City of Portland, Maine - Building or Use Permit Application
 389 Congress Street, 04101 Tel: (207) 874-8703, Fax: (207) 874-8716

Permit No: 02-1304 Issue Date: NOV 21 2002 CBL 30 F007001

Location of Construction: 3 Iffley St	Owner Name: Franklin Wayne H &	Owner Address: 3 Iffley St	Phone: CITY OF PORTLAND
Business Name:	Contractor Name: McLellan Construction	Contractor Address: 40 Waterville St Portland	Phone: 2072326334
Lessee/Buyer's Name	Phone:	Permit Type: Additions - Dwellings	Zone: R-3

Proposed Project Description: Ammend permit #021061 to build 26 x26 attached garage	Signature:	Signature: <i>JMB 11/21/02</i>
PEDESTRIAN ACTIVITIES DISTRICT (P.A.D.)		
Action: <input type="checkbox"/> Approved <input type="checkbox"/> Approved w/Conditions <input type="checkbox"/> Denied		
Signature:		Date:

GARAGE SECTION

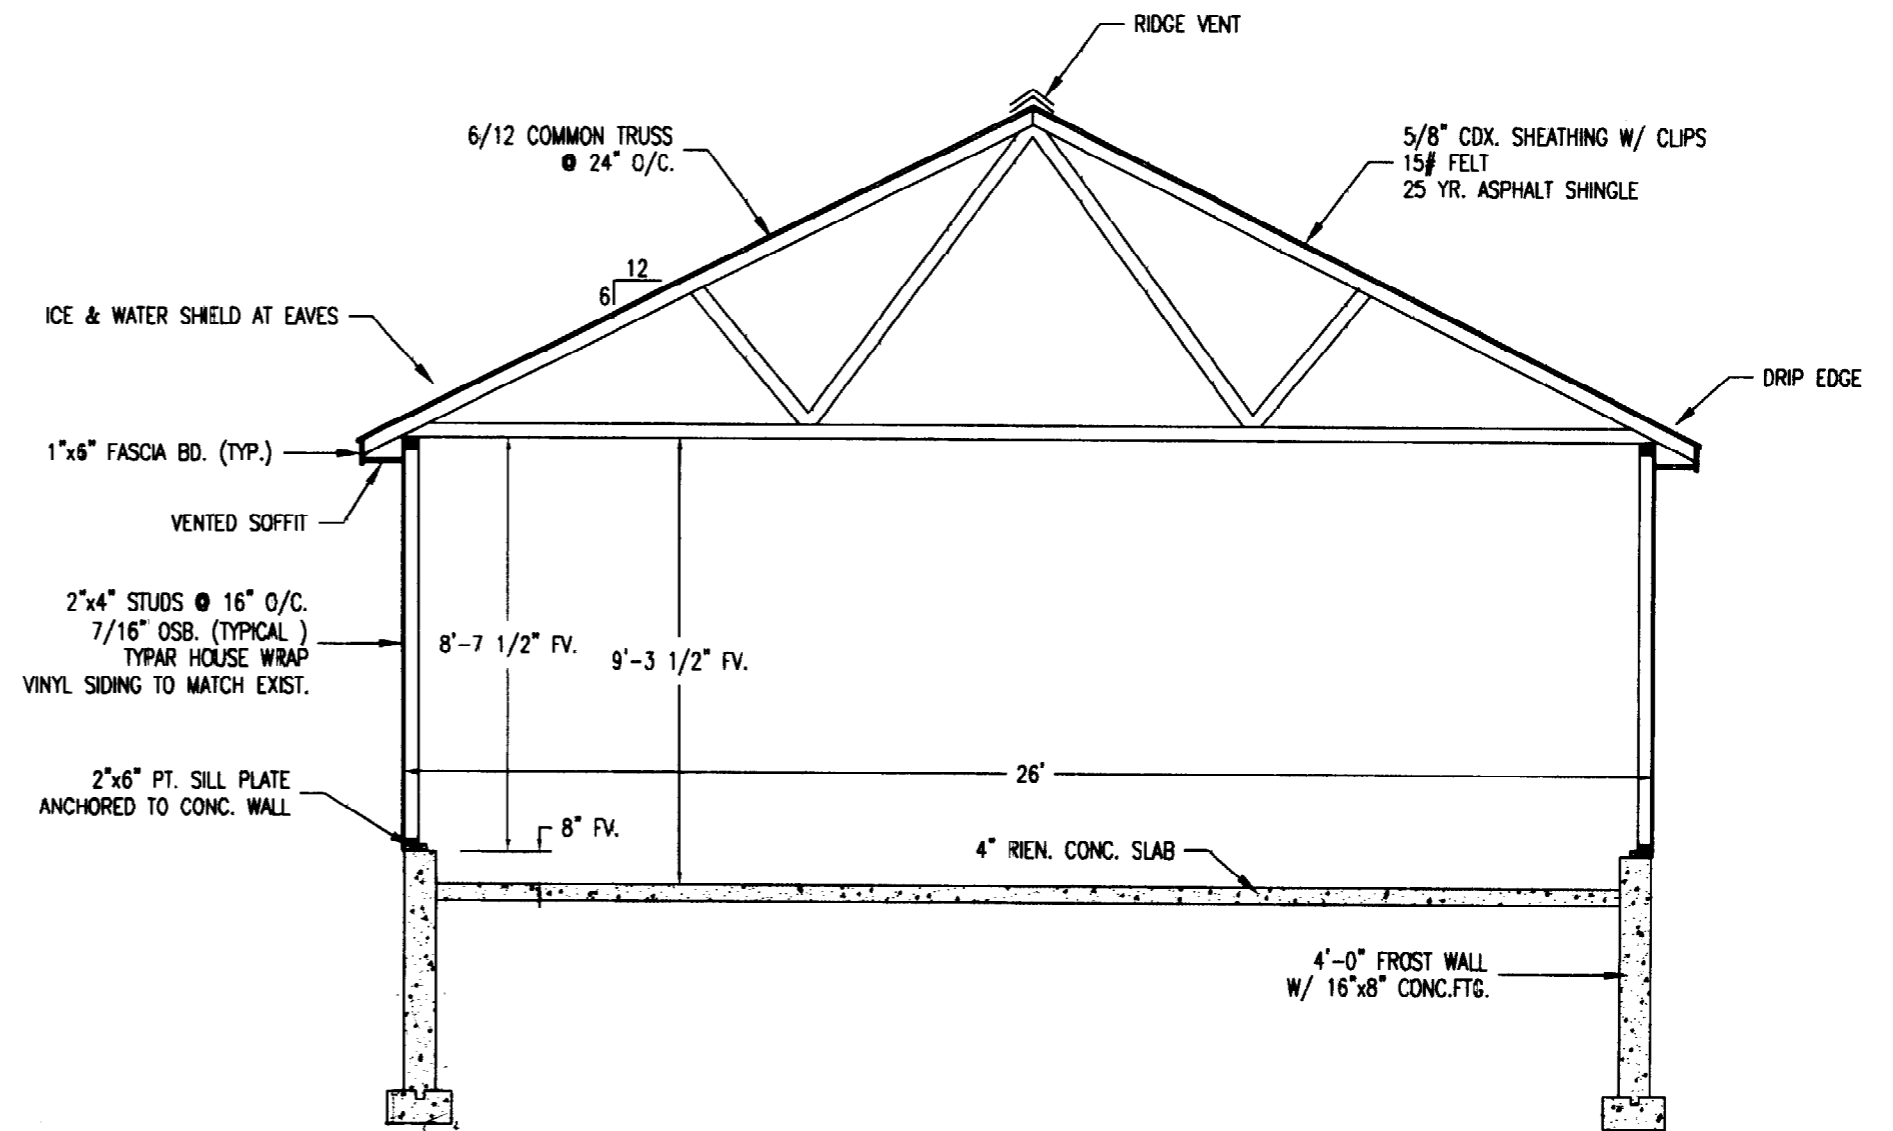
DATE	TIME	CONTACT	NARRATIVE	INITIALS
			① Truss spec	
			② Headers - etc + windows + door	
			③ Stairs	
			④ Guardrails	
			⑤ Header over garage door - needs to be	
			⑥ 4" and space from combustibles for chimney -	
			11/20/01 Spoke w/ Mary Franklin -	
			She'll address all of the above	
			and bring info in for me.	
			11/20/01 Spoke w/ Wayne Franklin	
			will get info - not doing	
			work until Spring - <u>NO RUSH</u>	
			1/18/02	
			1m a.m. to get more	
			info, and we will have	
			to delay until	
			he is ready to	
			move forward	
			2/12 1:00pm Wayne	
			would like to do	
			foundation -	
			207-415-4804 Wayne	
			call - having problems	
			getting contractor so they	
			can answer structural questions
